CITY OF ALBUQUERQUE

December 1, 2015

**Re: Juan Tabo Hills Estates request for CLOMR
Engineer's Stamp Date-no stamp- (M21D018)**

Based upon the information provided in your submittal received 11-12-15, the above referenced CLOMR cannot be submitted to FEMA until the following comments are addressed:

PROJECT Juan Tabo Hills West
SUBJECT Section 6
BY JPH DATE 12-17-13
CHECKED _____ DATE _____
SHEET _____ OF _____

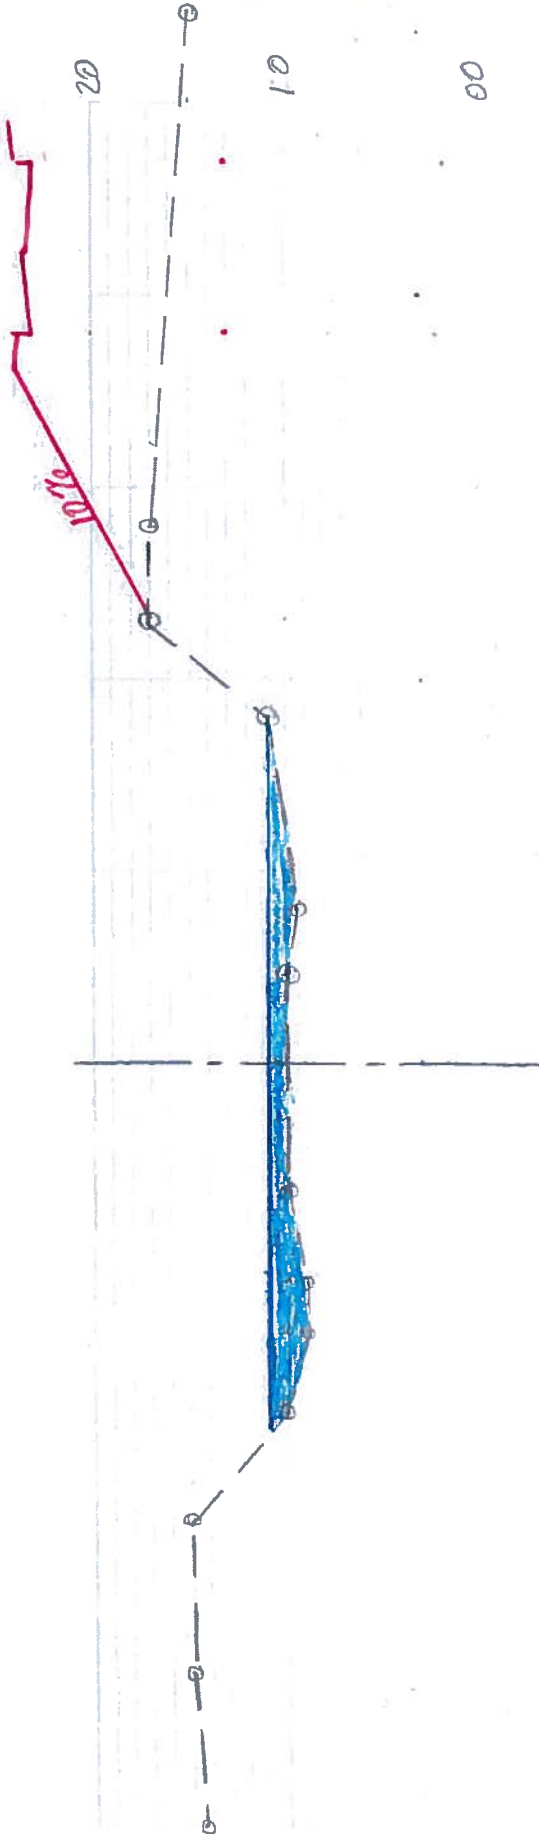
8. Show the scour wall in section 6.
9. Numerous more cross-sections are required. At a minimum every cross-section location on the plan and every FIS cross section. See comment #2 for extents.

**GRADING & DRAINAGE PLAN**

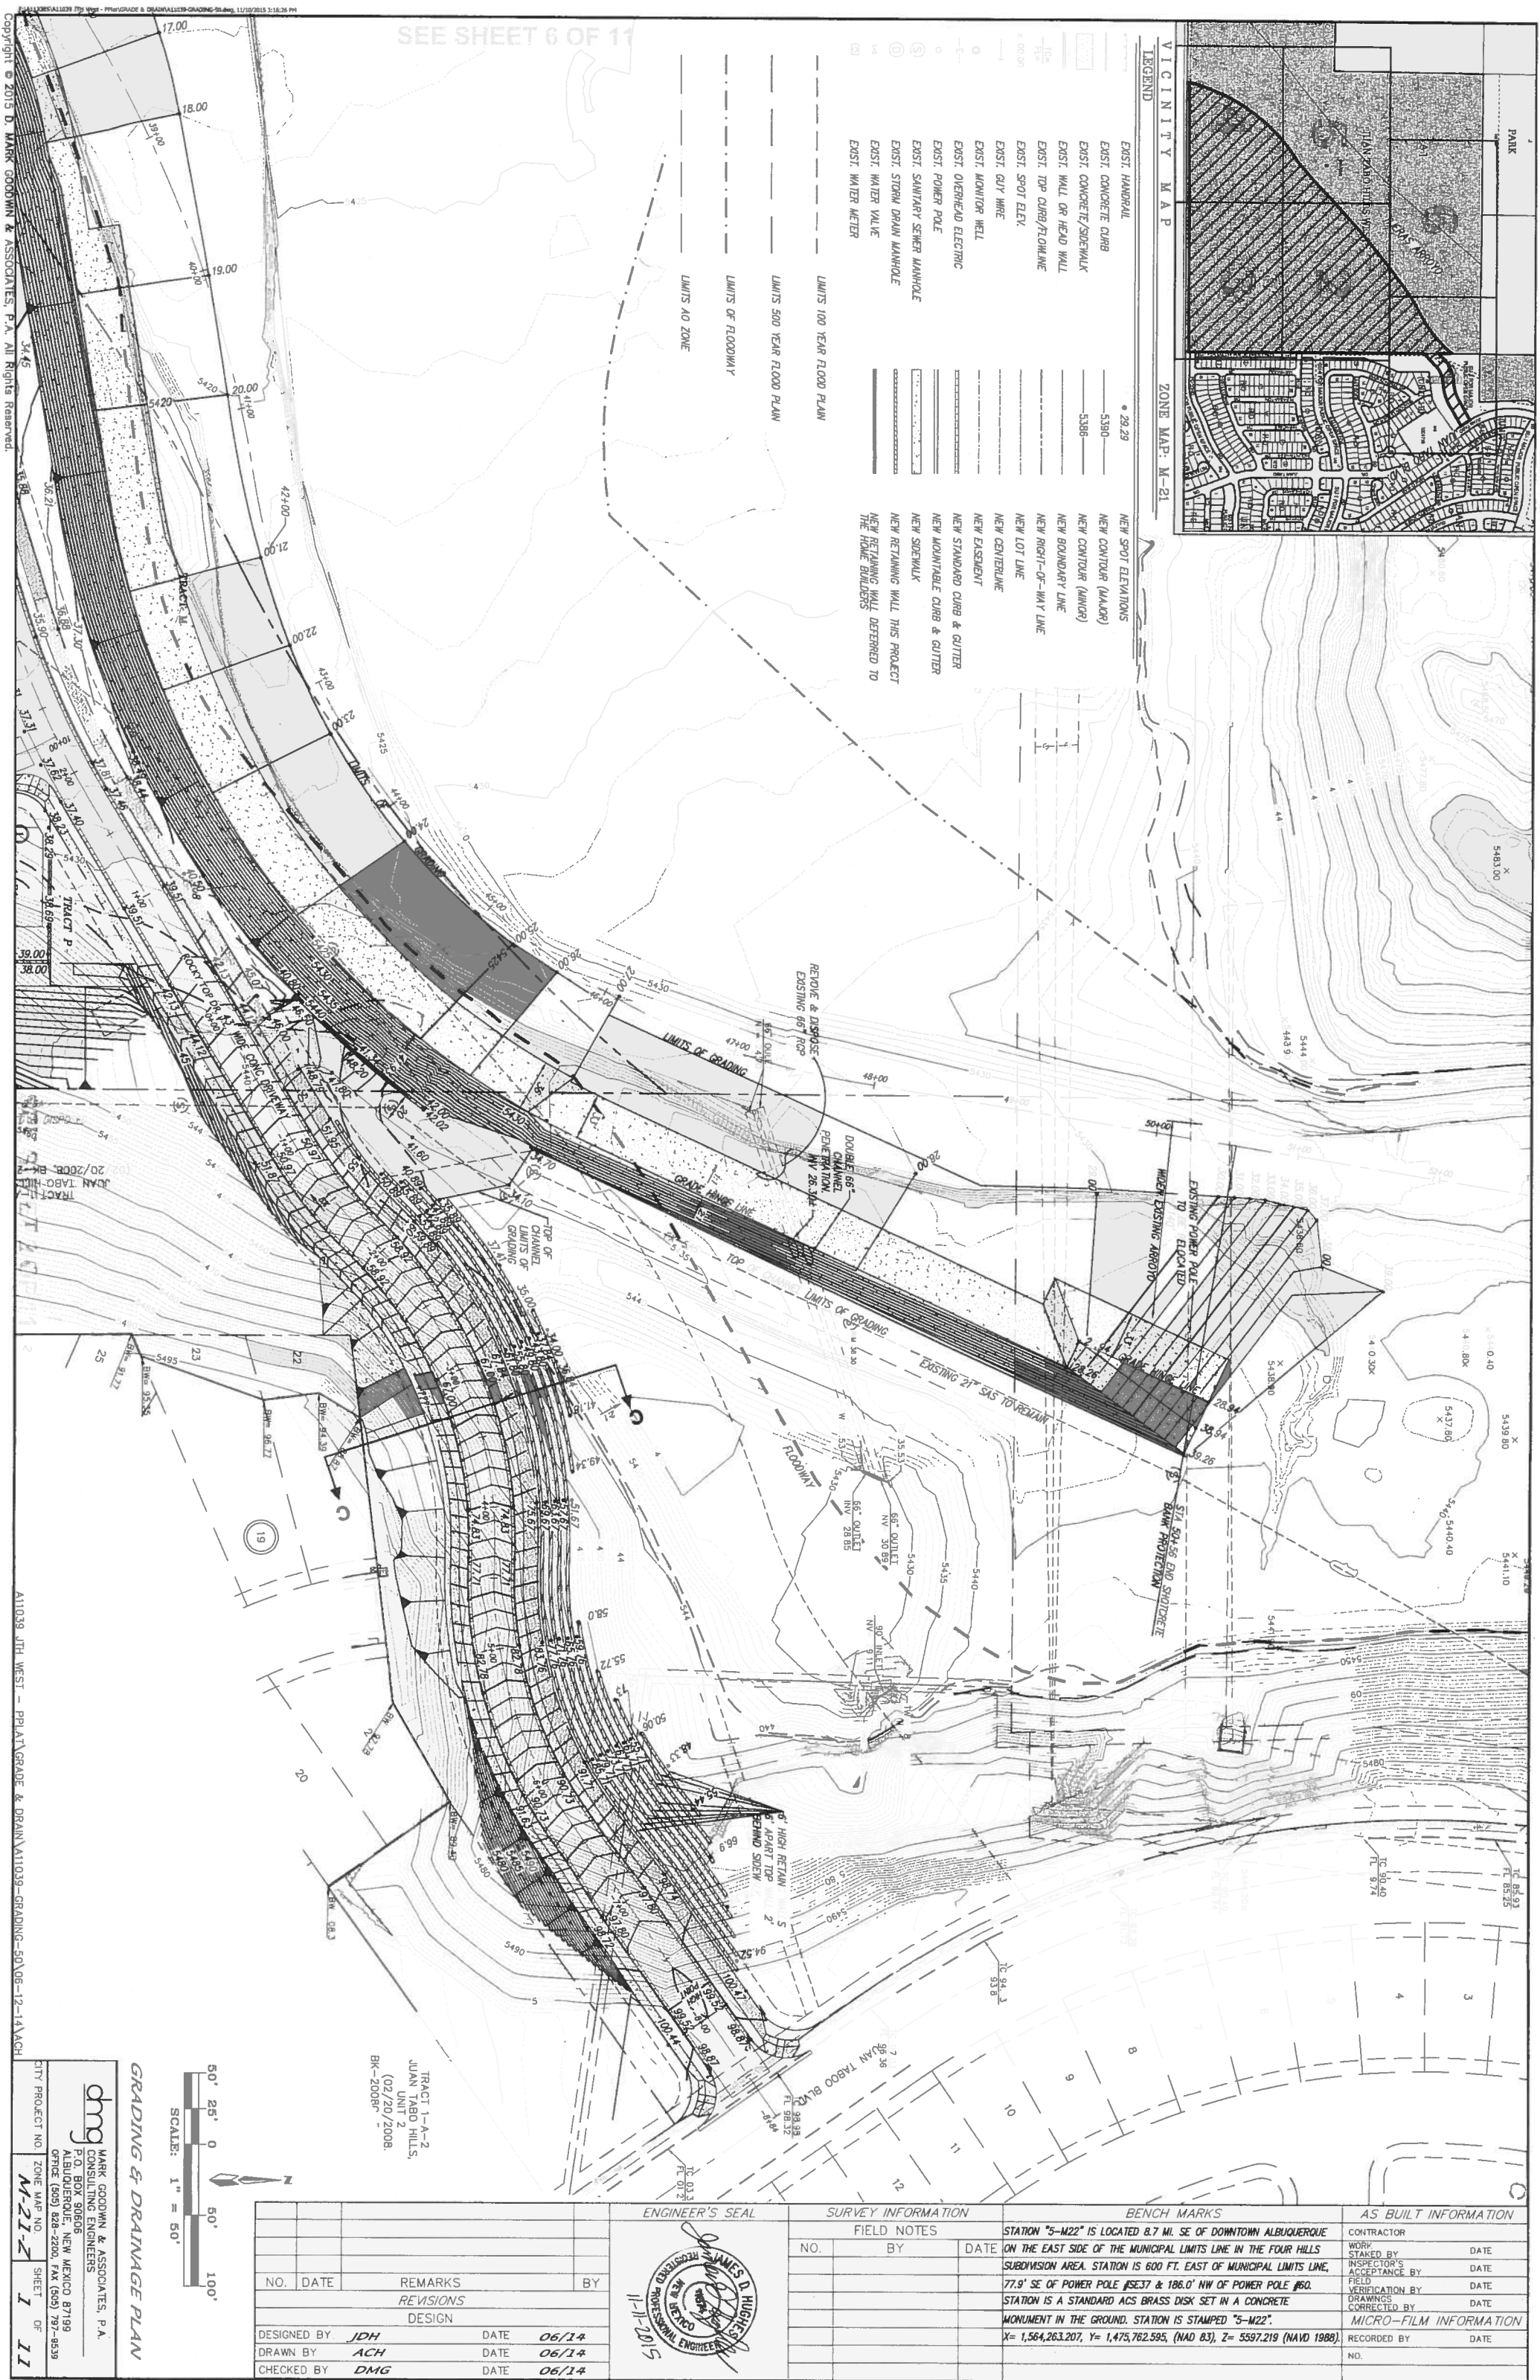
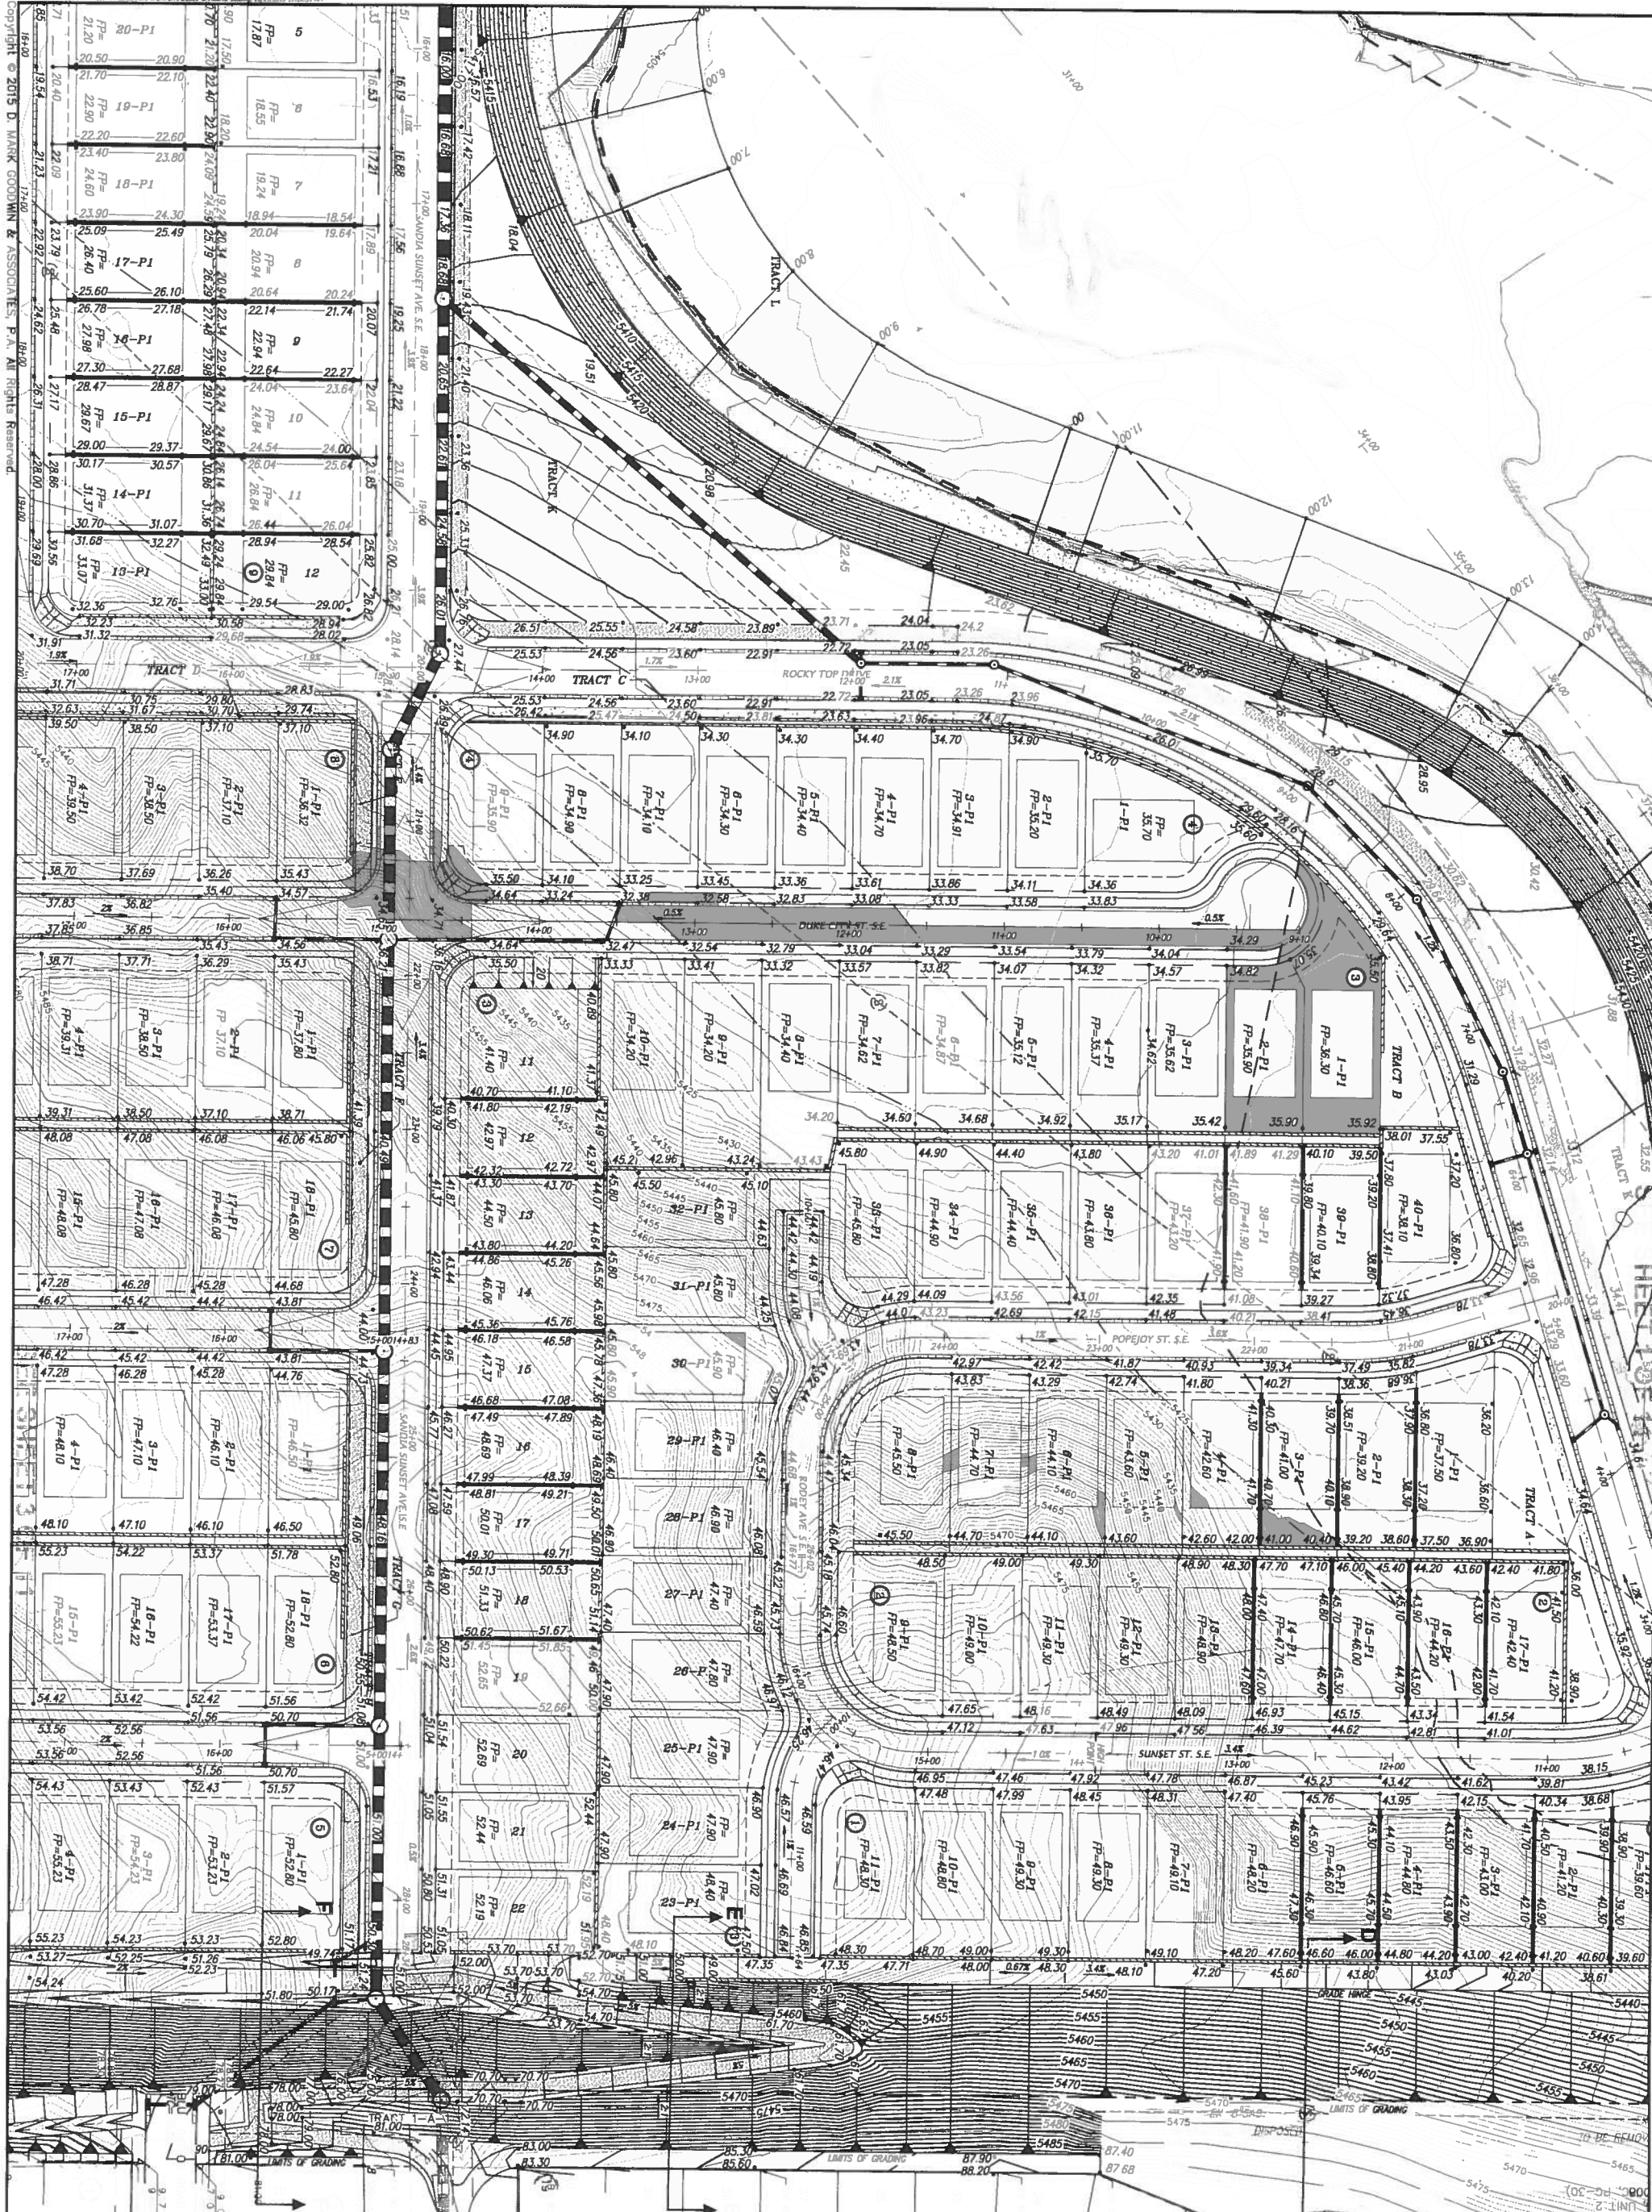
10. The Annotated FIRM is to be revised based upon above mentioned comments.
11. The following comments on the grading plan are related to the CLOMR.
 - a. At the northern end of the project, the scour wall is shown near the middle of the floodway and stops without tying into anything. What is to prevent the scour wall from being flanked? The scour wall should be closer to the edge of the floodway.

- b. Why is 8 to 10 feet of cut proposed at the north end? This will cause a head-cut to develop and result in erosion of the arroyo bed and additional sediment deposition downstream.

- c. Why is the arroyo bed proposed to be cut 5 feet or more from station 15+00 to 19+00? This will cause a head-cut to develop and result in erosion of the arroyo bed and additional sediment deposition downstream.

- d. Why is the arroyo bed proposed to be cut up to 9 feet near the SWQ pond? This will cause a head-cut to develop and result in erosion of the arroyo bed and additional sediment deposition downstream.

- e. A 4" outlet pipe seems extremely small for this size of a development.
 - f. There is some line work that looks like a storm drain south of the 4" pipe, but there is no build note.

- g. The bottom of the SWQ pond is below the water surface elevation of the arroyo. FEMA may consider the scour wall as a levee. The SWQ pond could be proposed as an AE zone (non-floodway), which may negate levee requirements. It is recommended to not propose a levee as the construction and design criteria is stricter than if a levee is not proposed.

- h. Please explain why it is necessary to propose so much cutting of the arroyo bed. The City would prefer to see a design that does not cut the arroyo bed to this extent, especially without grade control. The project site has lots of elevation gain above the arroyo. Why doesn't this design just increase in grade from the existing channel edge elevation?

- i. At station 15+60, an arroyo bed elevation of 84 is proposed, which is 8 feet lower than the arroyo bed elevation at station 14+75. The grading plan does not show the proposed grades from 84 to 92 and why is a hole proposed?

- j. Provide erosion protection where the 66" storm drains enter the arroyo. Provide method and calculations. An acceptable method is shown in "Urban Storm Drainage Criteria Manual, Volume 2" from Denver Colorado.

- k. Erosion protection criteria specified in comment J above also applies to the outlet(s) from the SWQ pond and additional outlets to the arroyo.
 - l. A different line type for the floodway is shown on the east side of the floodway.

- m. Once the WSE elevation is corrected to NAVD 88, the WSE can be compared to the grading plan.
